City of Portland, Maine - Building or Use Permit Application
 389 Congress Street, 04101 Tel: (207) 874-8703, Fax: (207) 874-8716

Permit No: 06-0168	Issue Date:	CBL: 061 H012001
------------------------------	--------------------	----------------------------

Location of Construction: 354 DANFORTH ST	Owner Name: SANFORD KAREN R	Owner Address: 354 DANFORTH ST	Phone:
Business Name:	Contractor Name: Joe Lucey	Contractor Address: 482 Walnut Hill Rd No Yarmouth	Phone 2076714249
Lessee/Buyer's Name	Phone:	Permit Type: Alterations - Dwellings	Zone:

Past Use: Residential 2 unit	Proposed Use: Residential 2 unit re-sheath side porch rebuild railings, install new treads on stairs	Permit Fee: \$57.00	Cost of Work: \$3,320.00	CEO District: 2
Proposed Project Description: re-sheath side porch, rebuild railings, install new treads on stairs		FIRE DEPT: <input type="checkbox"/> Approved <input type="checkbox"/> Denied	INSPECTION: Use Group: Type	
		Signature:	Signature:	
PEDESTRIAN ACTIVITIES DISTRICT (P.A.D.)				
Action: <input type="checkbox"/> Approved <input type="checkbox"/> Approved w/Condition <input type="checkbox"/> Denied				
		Signature:	Date:

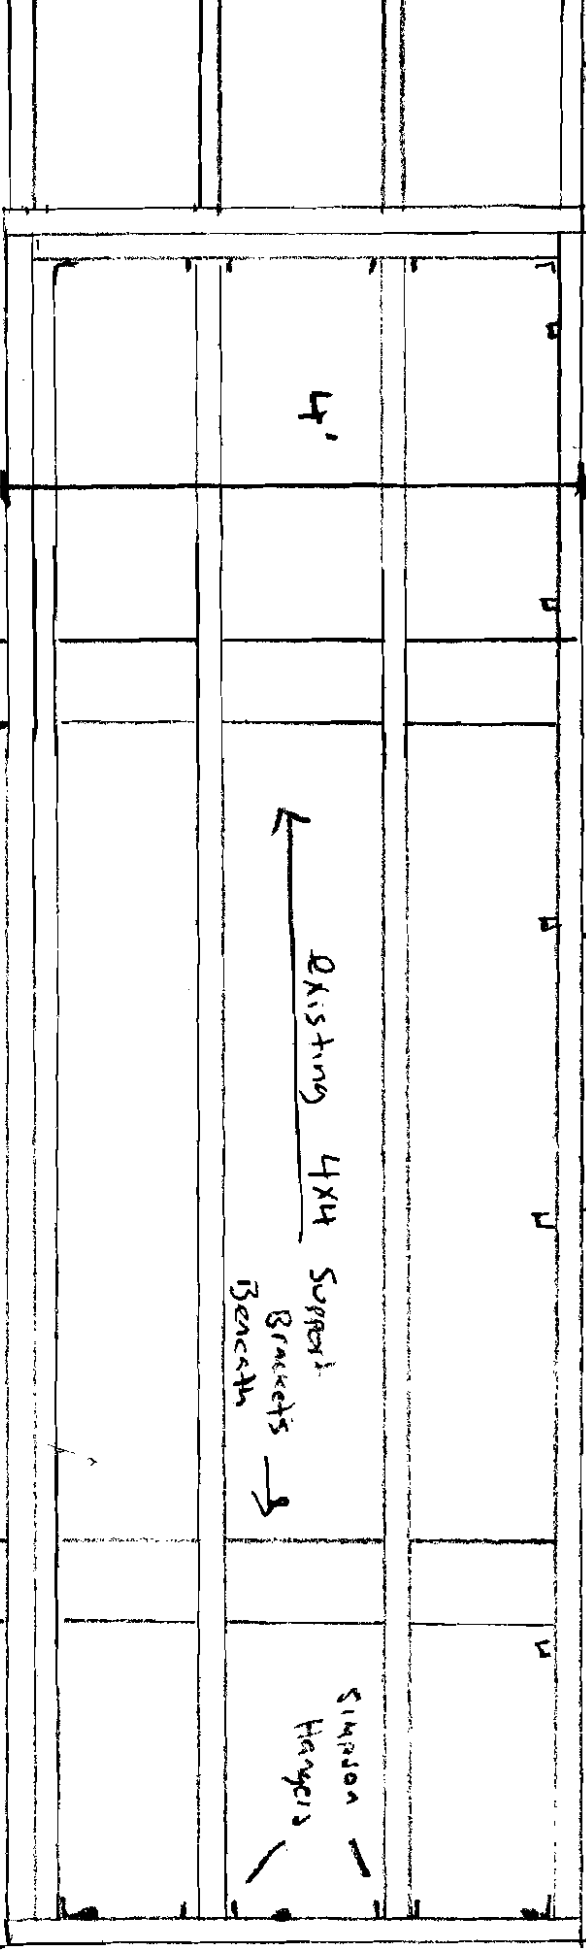
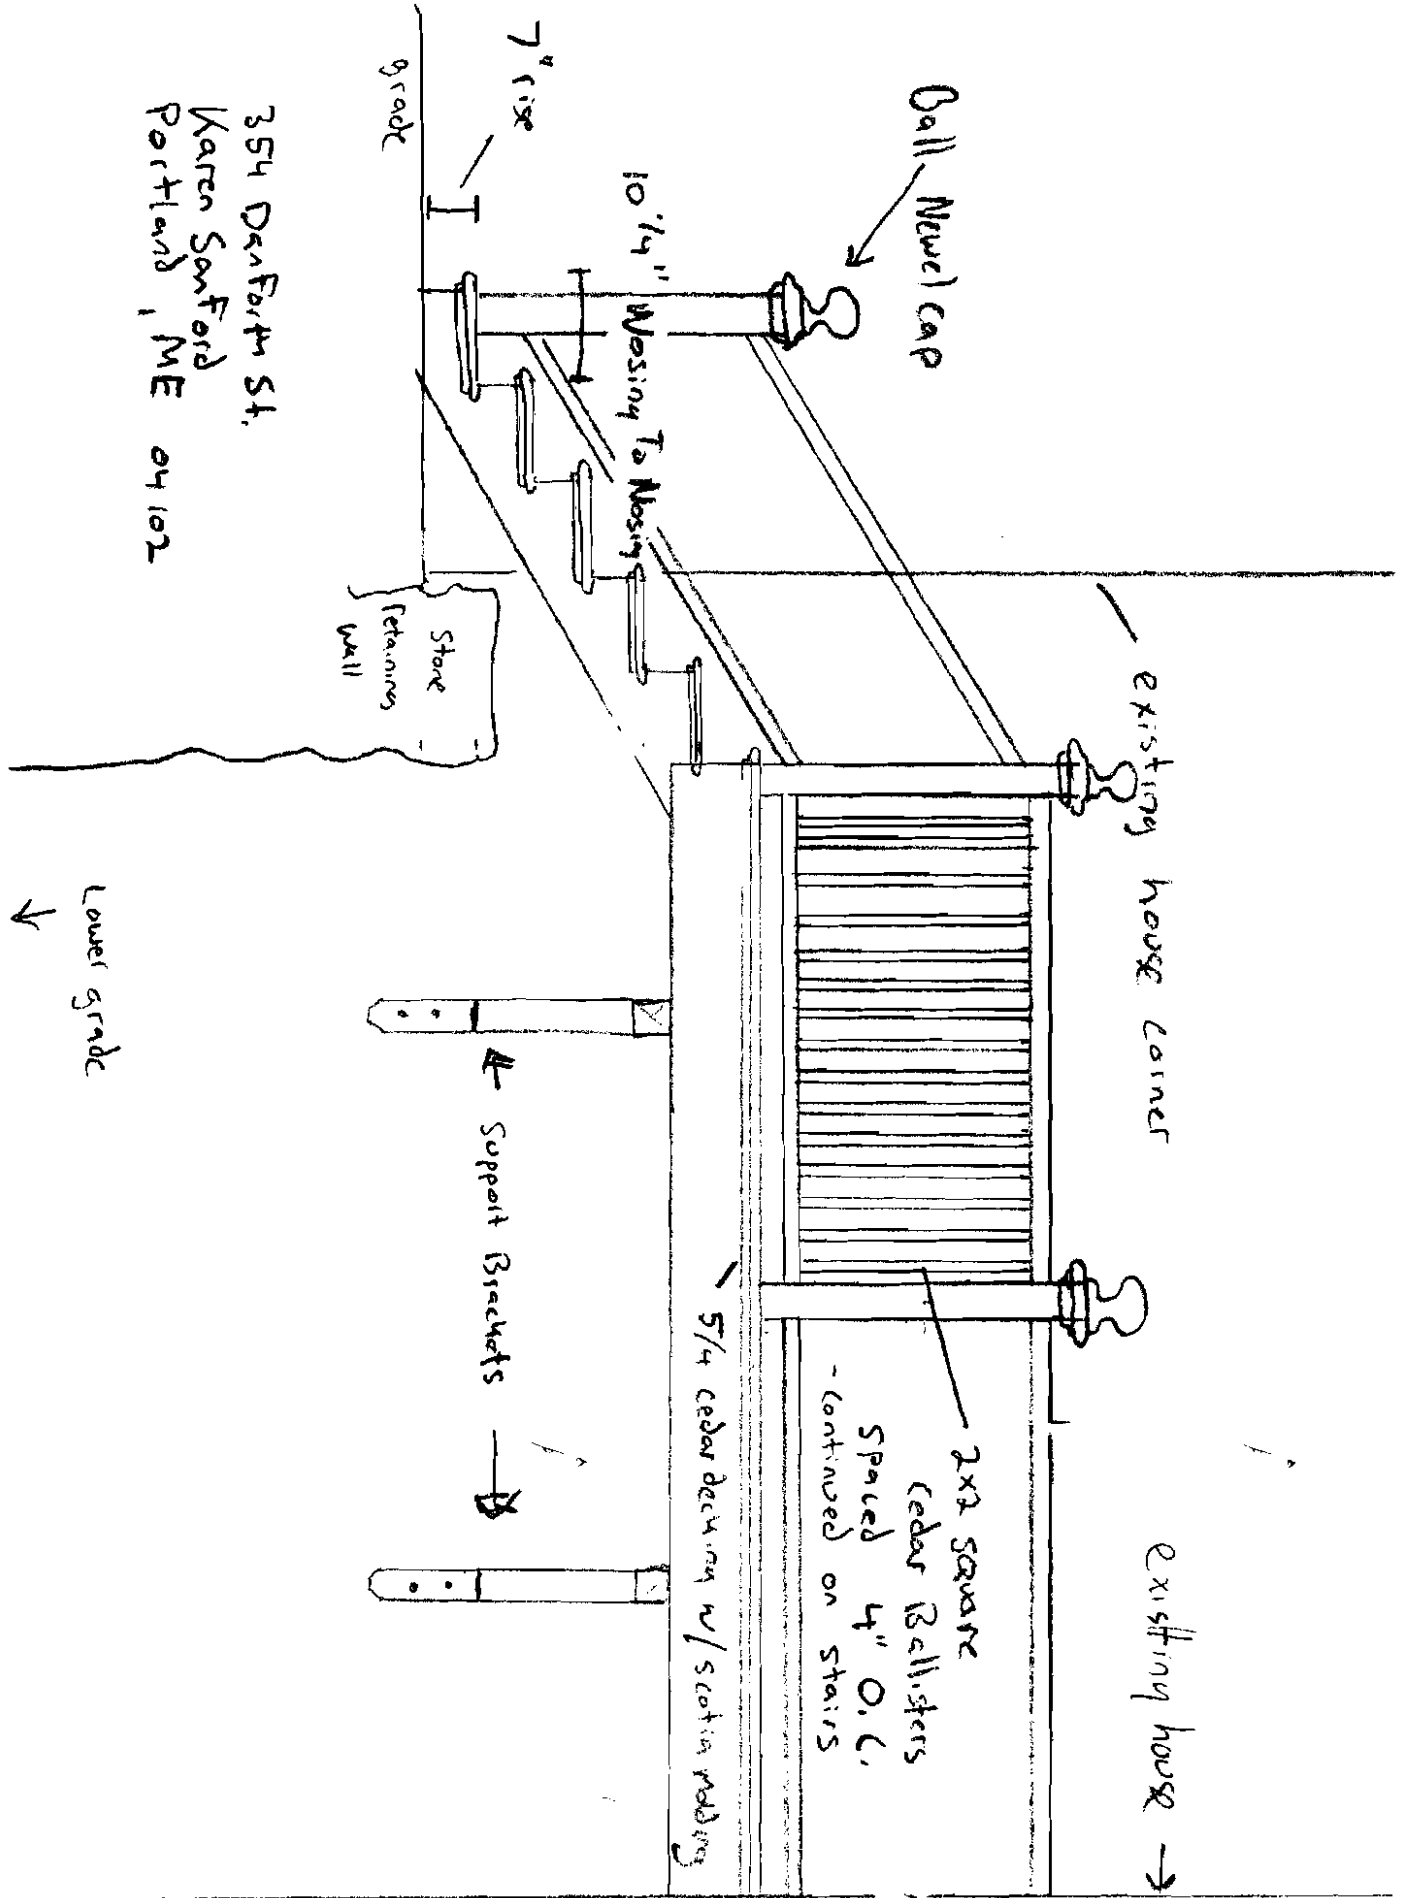
1) The porch must remain in the existing footprint			
Dept: Building	Status: Approved with Conditions	Reviewer: Jeanine Bourke	Approval Date: 03/13/2006
Note:	Ok to Issue: <input checked="" type="checkbox"/>

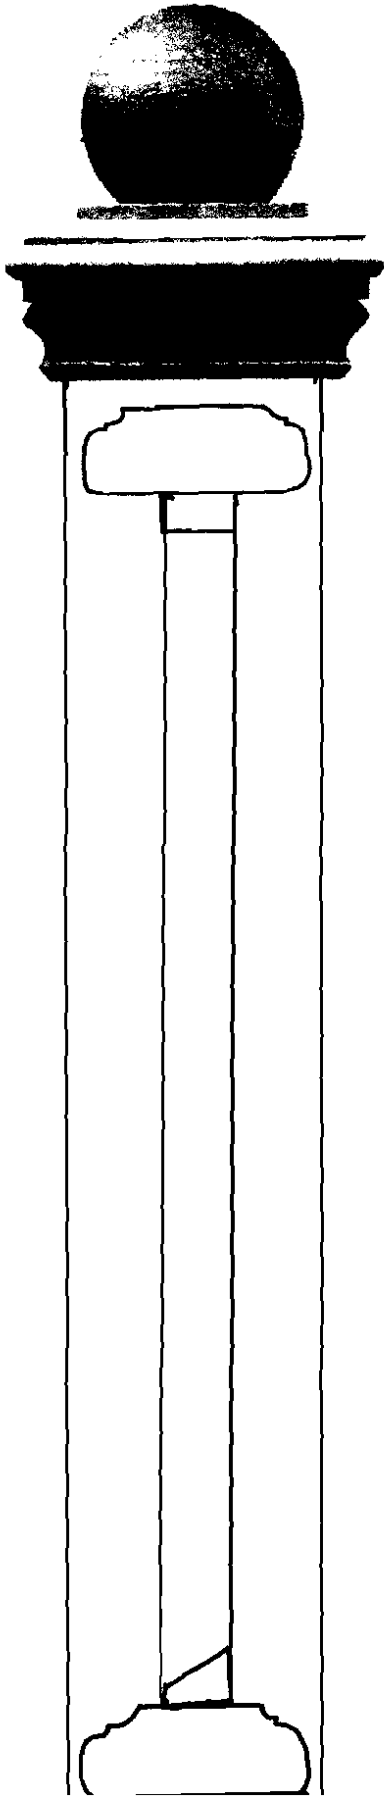
1) "Newport Classic" flat cap to be used in place of cap with ball initially proposed.			
Dept: Zoning	Status: Approved with Conditions	Reviewer: Jeanine Bourke	Approval Date: 03/13/2006
Note:	Ok to Issue: <input checked="" type="checkbox"/>
